## **Green Hill Solar Farm**

### **Comments on Traffic and Construction**

The Outline Construction Traffic Management Plan (OCTMP) dated May 2025 has now been reviewed by myself, and I wish to raise the following comments.

Title:
Figure 13.5: Routes to Scheme Sites (South Area)

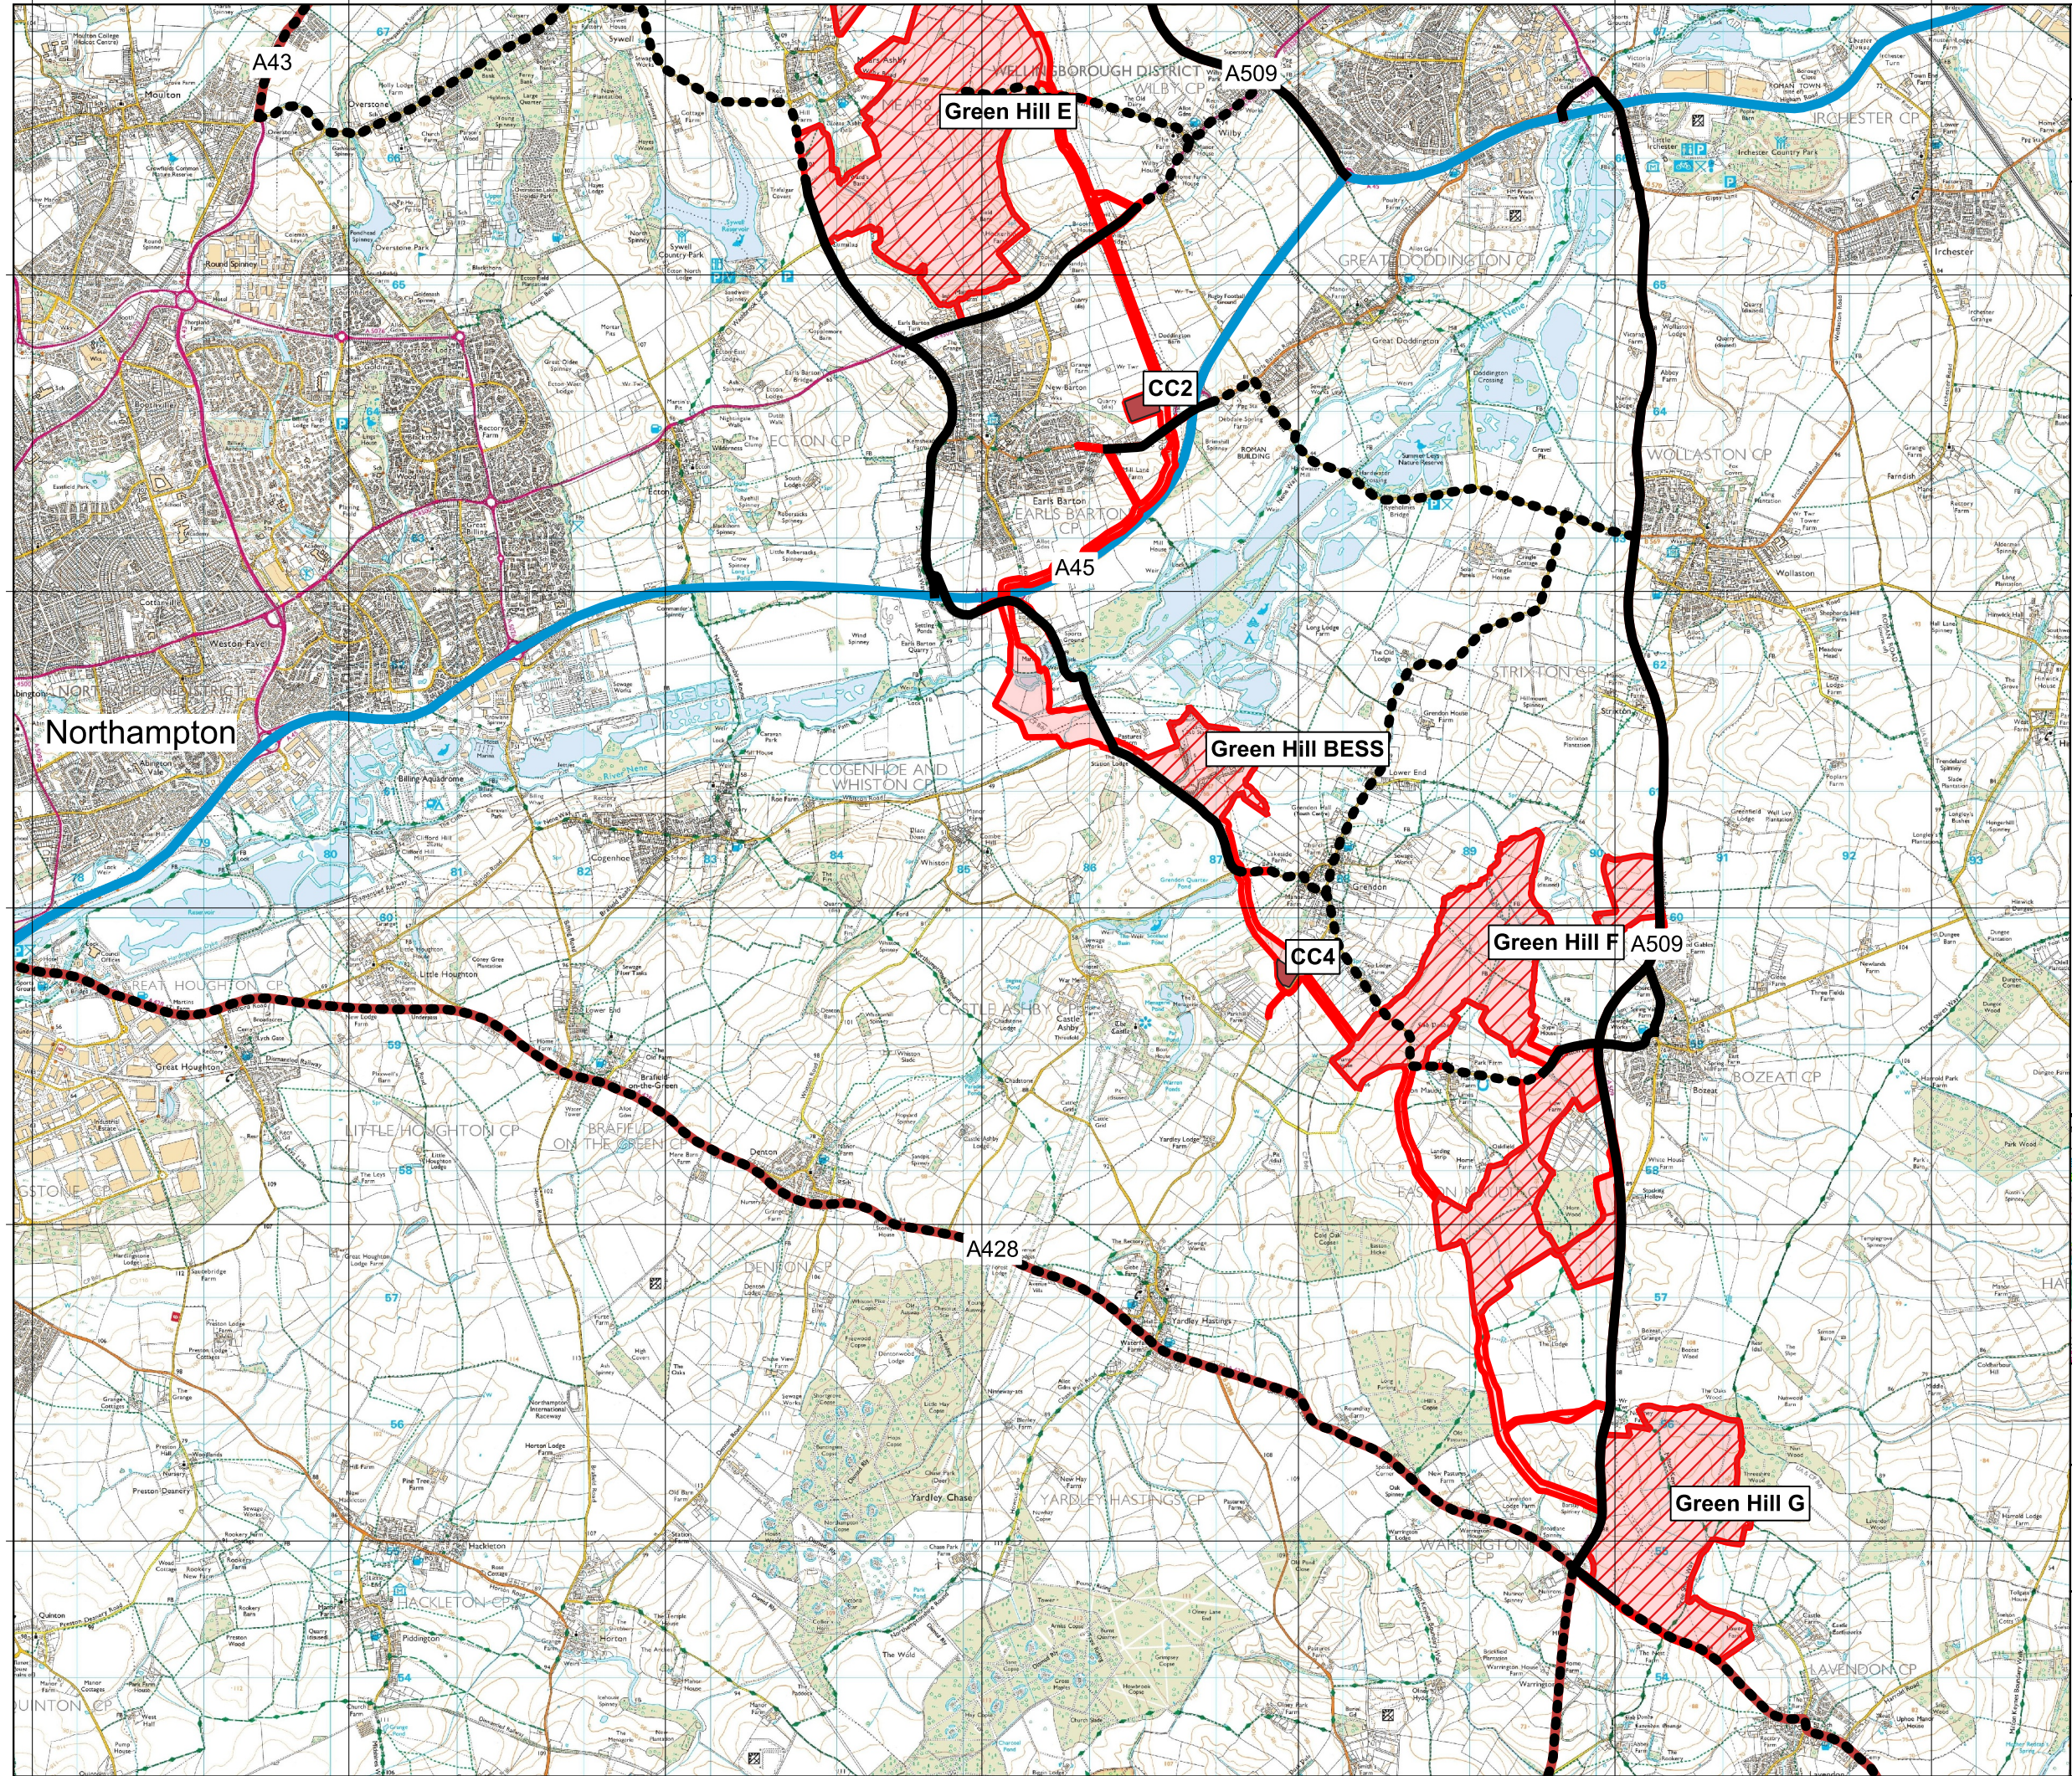
To travel to these access points, all traffic will have to come through the relatively narrow streets in the village of Bozeat, namely along the old A509 / London Road and turn into Easton Lane. This is a residential area and should not be used for several years of continual large vehicle movements or other construction traffic. It is totally unsuitable for the vehicles indicated in paragraph 3.1.2. The Construction Vehicle Routing is indicated in Section 4 later in the OCTMP and Figure 4.3 appears to confirm that it is the intention that construction traffic will be using London Road from the north end into the village and Easton Lane to access the site. (Additionally, I would question how construction traffic is to be stopped from accessing the village from the south end and using London Road to come through the village and to reach Easton Lane to reach Access F-2 and CR23 ?)

would use these access points in preference to others. The HGV traffic should use these access points and not be allowed into Bozeat village to access Easton Lane. However, as noted above, Figure 4.3 indicates that this is not the proposed plan. Table 7.1 indicates that Easton Lane would be used for abnormal loads of 95 tonnes; it is unlikely that the existing highway bridge over the A509 Bozeat bypass would be designed to take this weight and again one would question why these abnormal loads have not been planned to use Access F-1 and Access F-3 off the A509.

Title:
Figure 13.16: Access Locations for Sites and
Cable Route Corridor (South Area Part 2)

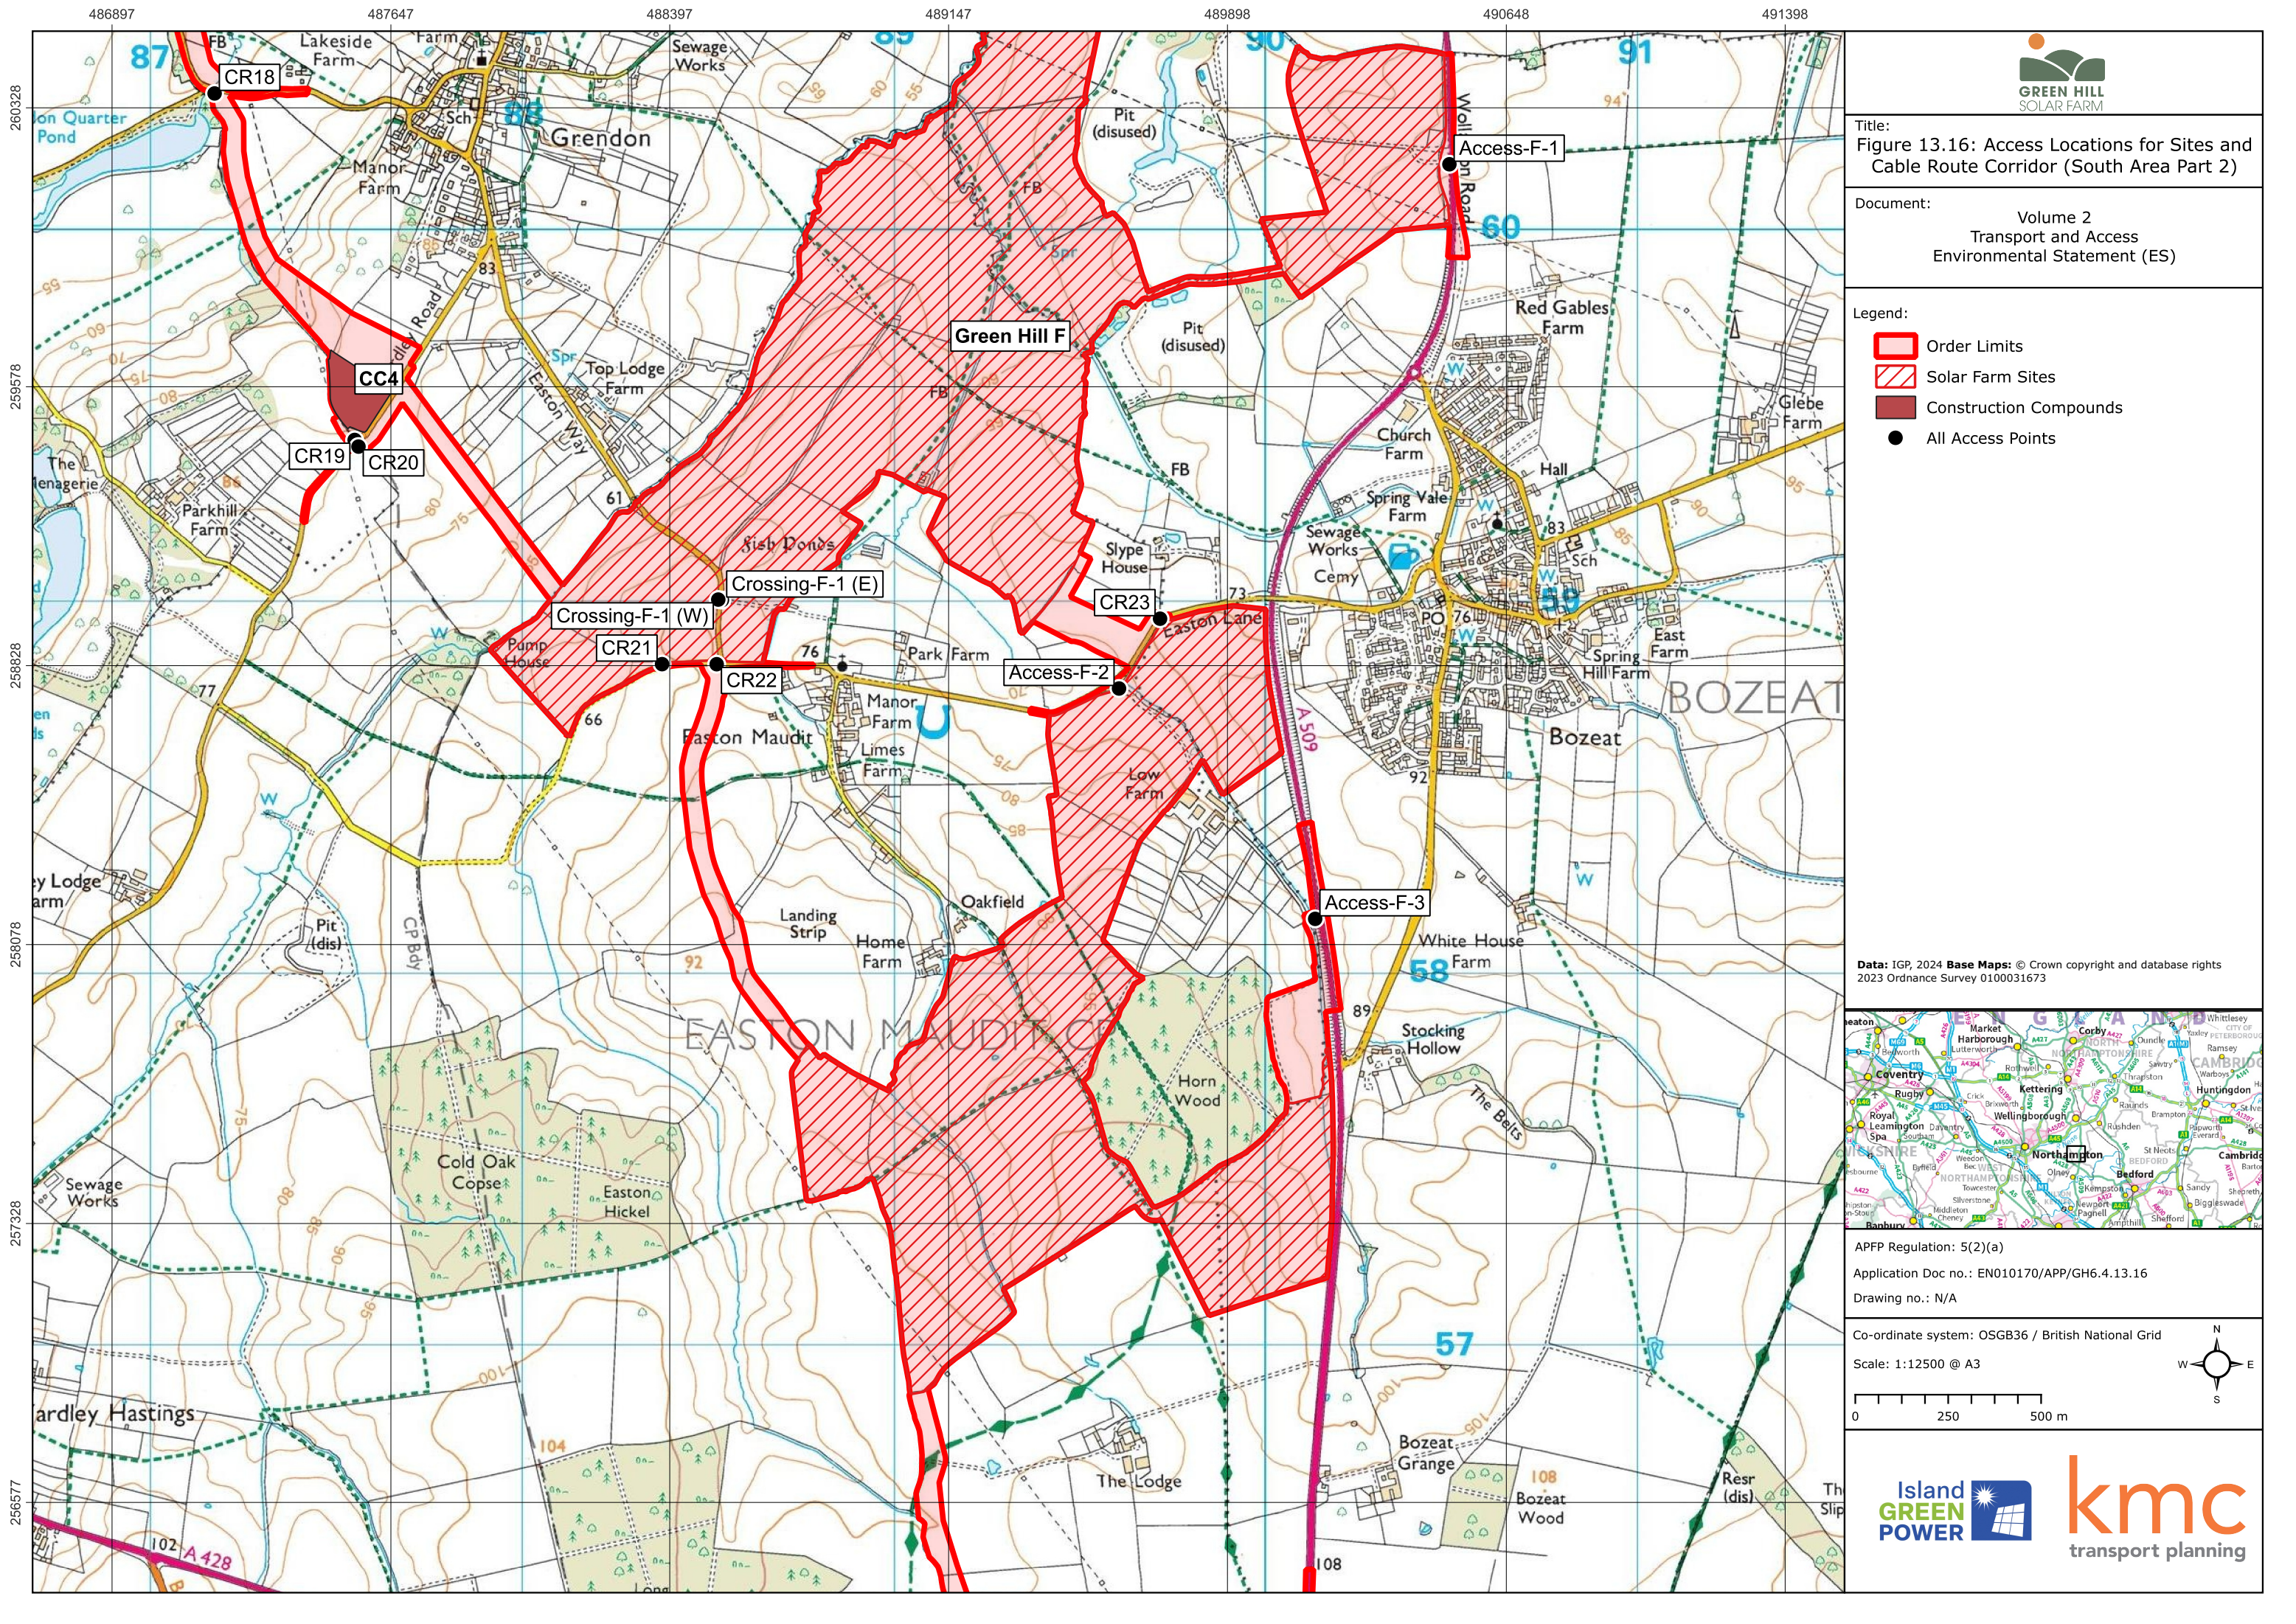
Access F-2 and CR23 are near our house but there are no specific details of the routes to / from them, or what types of vehicles would use them. What are the arrangements for the use of these access points ? It reads as if it will be free-for all, and this cannot be allowed to proceed in this way.

The issue that Easton Maudit is impassable to large lorries appears not to have been considered. The existing road from Bozeat to Grendon, via Easton Maudit, is not suitable for large construction traffic. It is also worth noting that Access CR21 is on a single-track road that is not suitable for any large traffic; this was pointed out at the public consultation and I was told that this was shown in error, but it is still on the current plans in the current OCTMP.

Paragraph 2.6.4 states that parking is to be at the Construction Compounds, but they are spread out and nowhere near the extremities of the works. For example, and not the worst example, but Access CR23 is approximately 3km from the nearest compound and I would question if workers are going to walk these distances ? This is unrealistic, impractical and not thought through.

Section 2.7 mentions internal haul routes, but these are not shown on the plans and there are no indications where these are to be constructed. If there are to be haul routes from Access F-1 and Access F-3, then Easton Lane would not have to be used for any construction traffic. (Note - the crossing F-1 has already been used for the advance works that took place in February / March 2025.) What plans are there for the long-term use of these crossings ? Will there be gates, with operatives in attendance, or will these be fitted with automatic traffic lights, and will these be operational for working hours only, and for how many days a week ? None of this information has been indicated. Without this information, as local residents, we cannot appreciate what affect the construction works will have on our day-to-day lives.
